CITY OF ALBUQUERQUE

RE: Olague Warehouse – 1212 3rd St. NW
Grading Plan
Stamp Date: 9/20/17
Hydrology File: J14D184

Based upon the information provided in your submittal received 9/19/17, the Grading and Drainage Plan **is not** approved for Building Permit. The following comments need to be addressed for approval of the above referenced project:

## GRADING & DRAINAGE PLAN

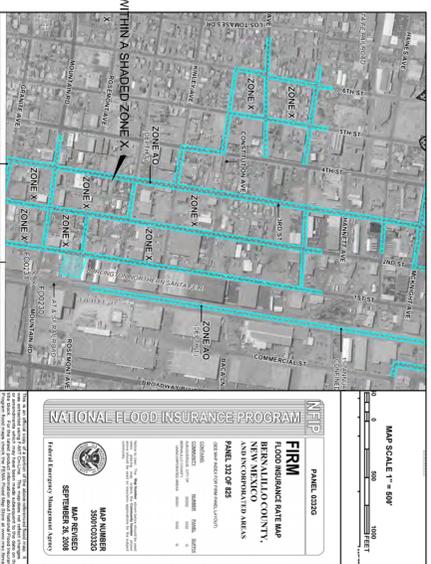
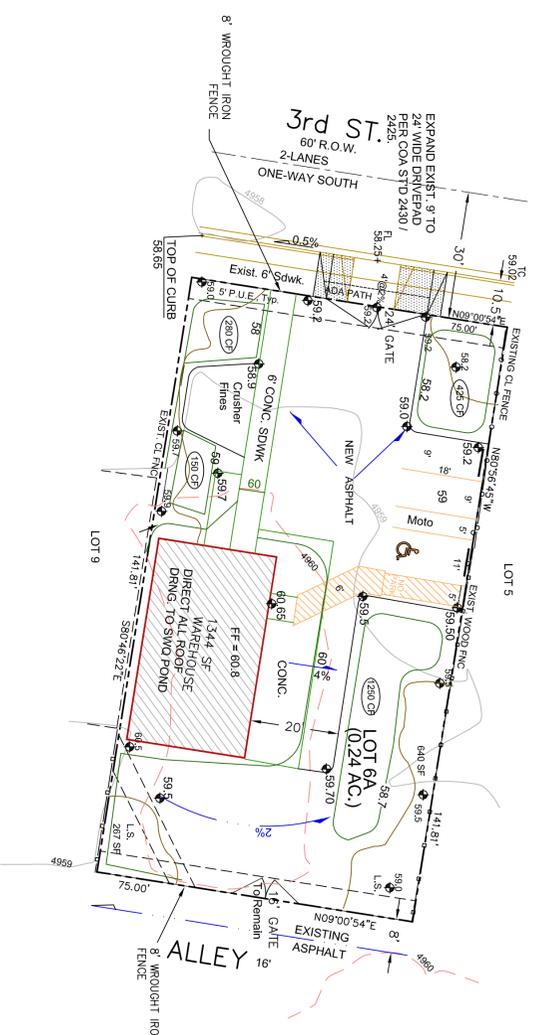
1. As per the DPM Chapter 22, Section 5.G (Flat Grading Scheme), The required 100 year 10 Day retention volume should have been 1,228 CF instead of the noted 1, 045 CF.
2. Please provide more detail and calculations for each retention pond, so the volumes can be verified.
